Date: 09 July 2020

RE: 19/05000/HYB | Hybrid application comprising, in outline: development of business space (use classes B1a/b/c) of up to 27,773 sqm GEA; works within the X enclave relating to energetic testing operations, including fencing, access, car parking; development of up to 635 residential dwellings; development of a mixed use village centre (use classes A1/A3/A4/A5/B1a/D1/D2); land safeguarded for a primary school; change of use of Fort Area and bunkers to Historic Interpretation Centre (use class D1) with workshop space and; associated landscaping, works and infrastructure. In detail: demolition of existing buildings; change of use and works including extension and associated alterations to buildings Q13 and Q14 including landscaping and public realm, and primary and secondary accesses to the site. | DSTL Fort Halstead Crow Drive Halstead Sevenoaks KENT TN14 7BU

Many thanks for your consultation on the above application.

TITLE  
**PROPOSED EXTERNAL ISOLINE CONTOURS FOR ARTIFICIAL LIGHTING**

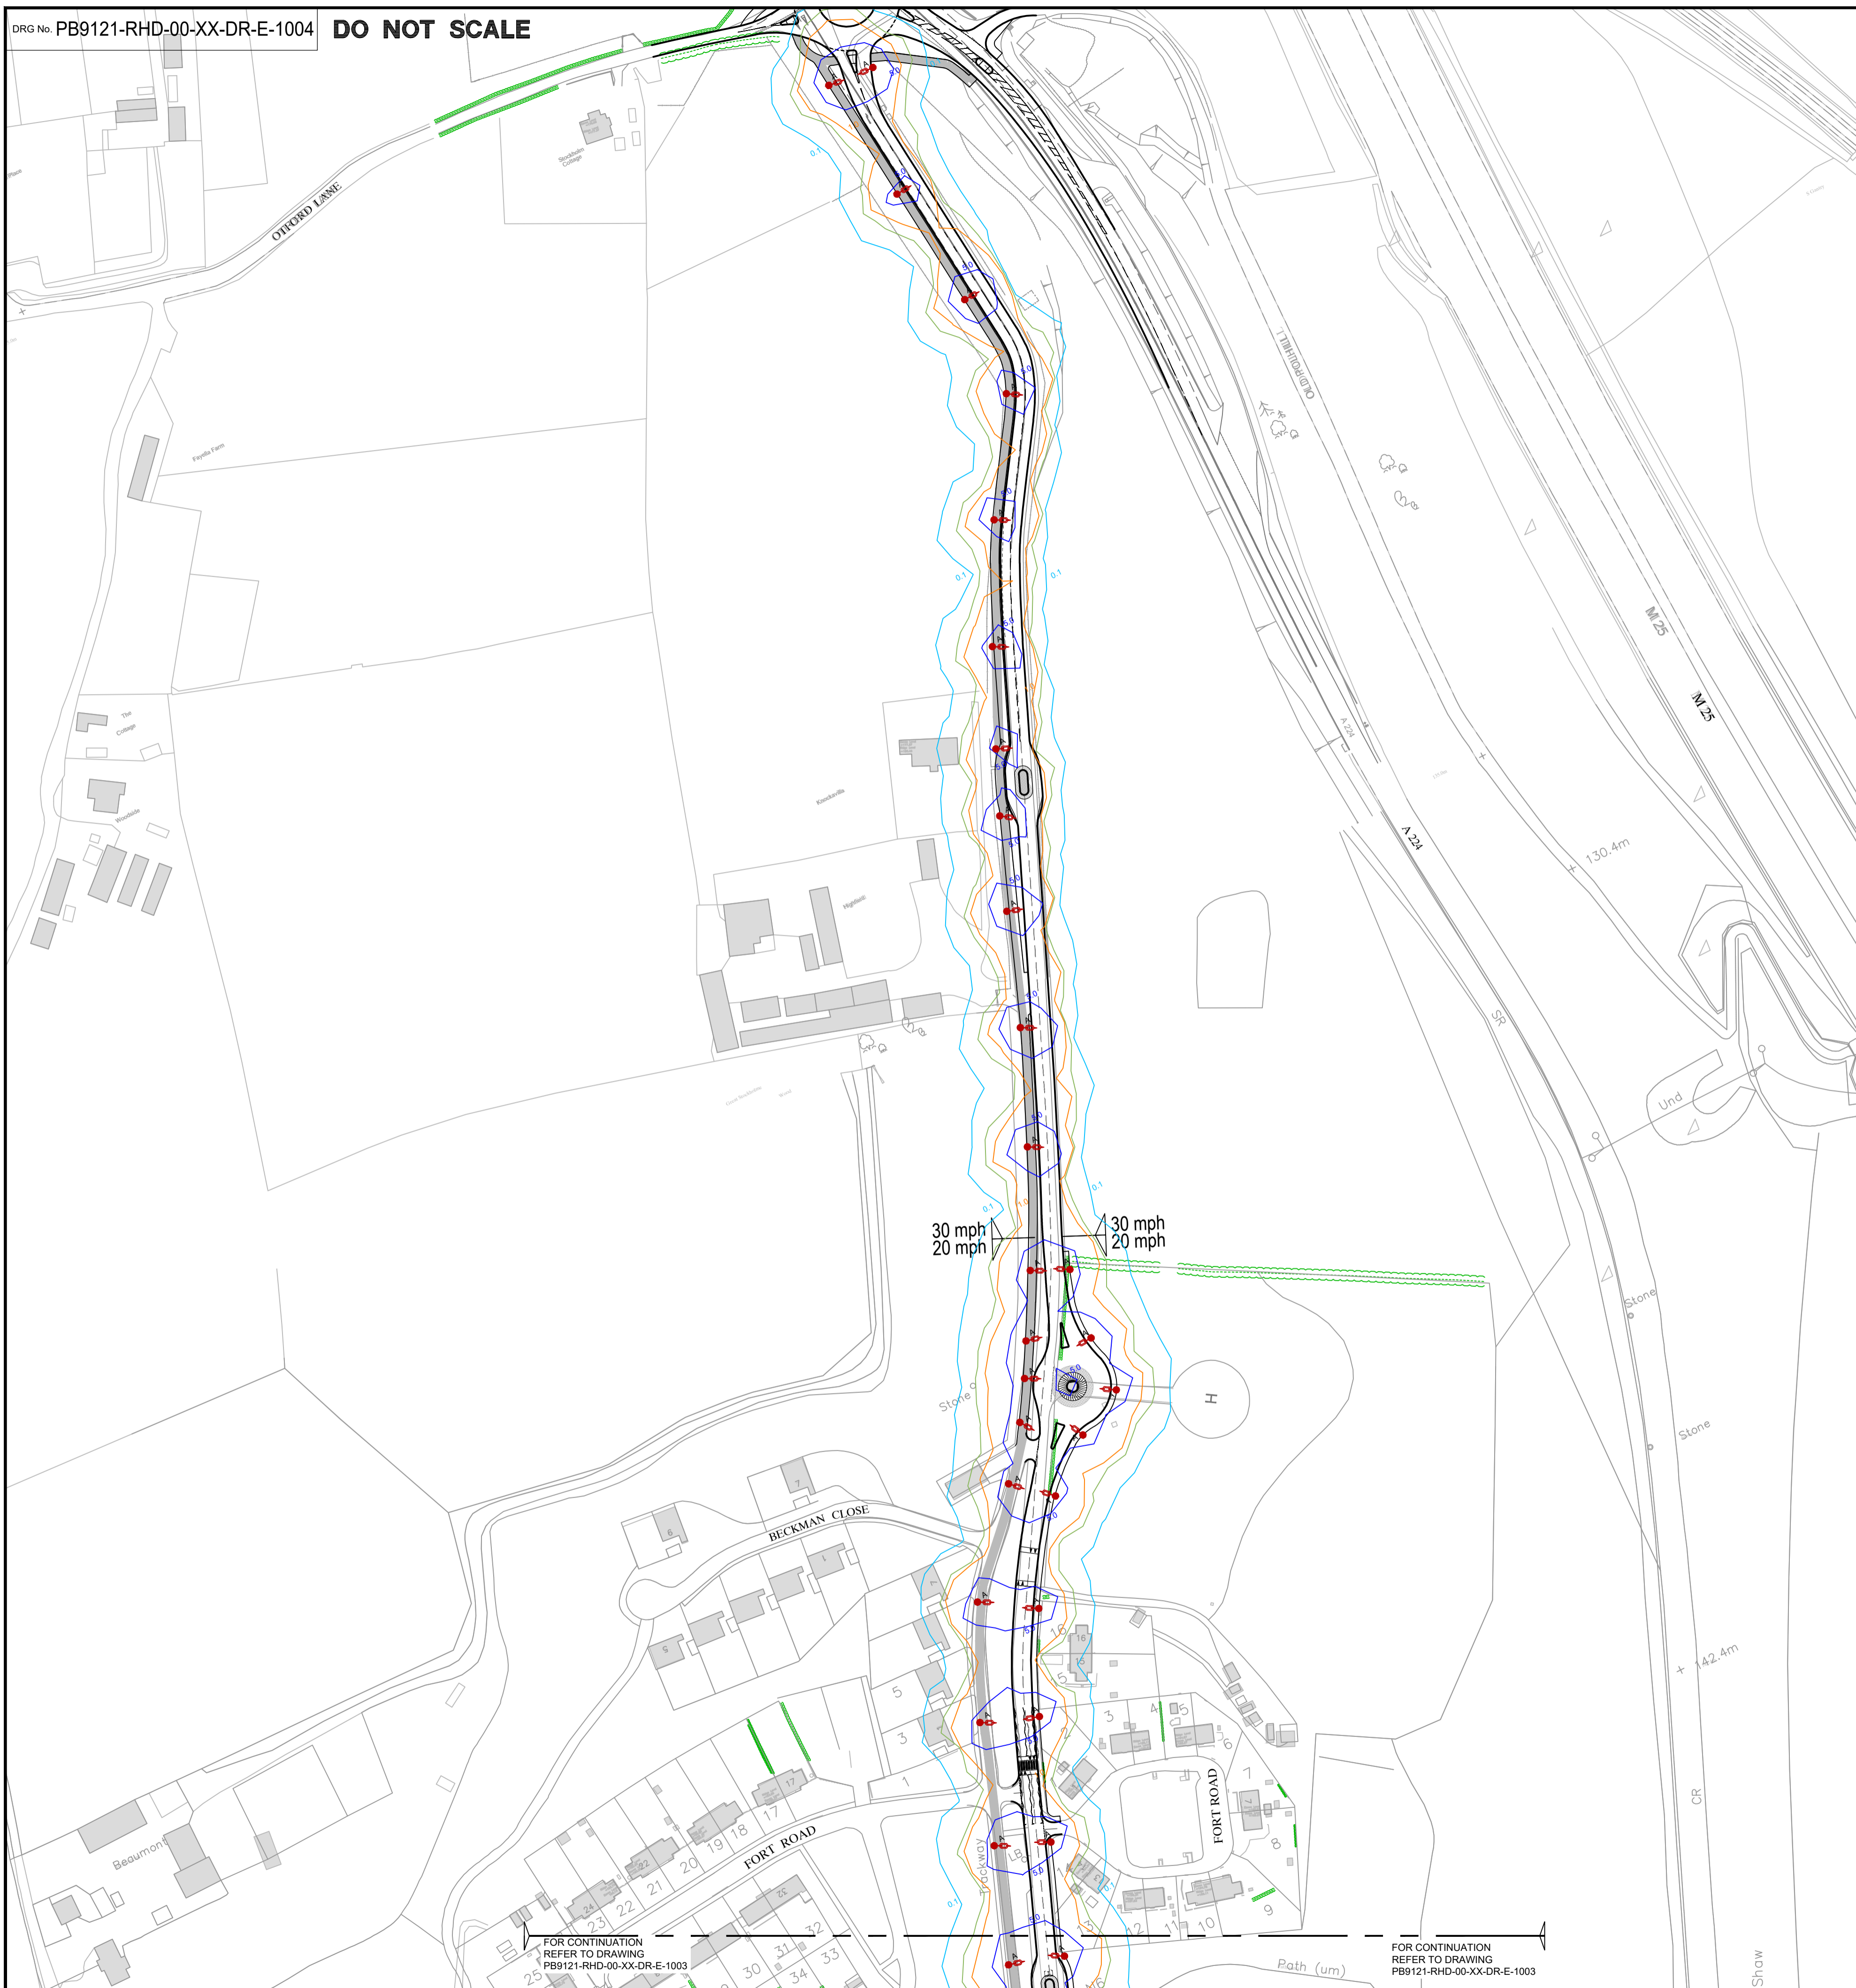
At present, the Technical Lighting Report does not appear to take account of ecological receptors. A suitable lighting strategy, which avoids light spill into ancient woodland and other sensitive receptors should be secured via a suitable condition. The lighting scheme should avoid areas where biodiversity enhancements are to be implemented, e.g. locations of bat boxes erected within the site.
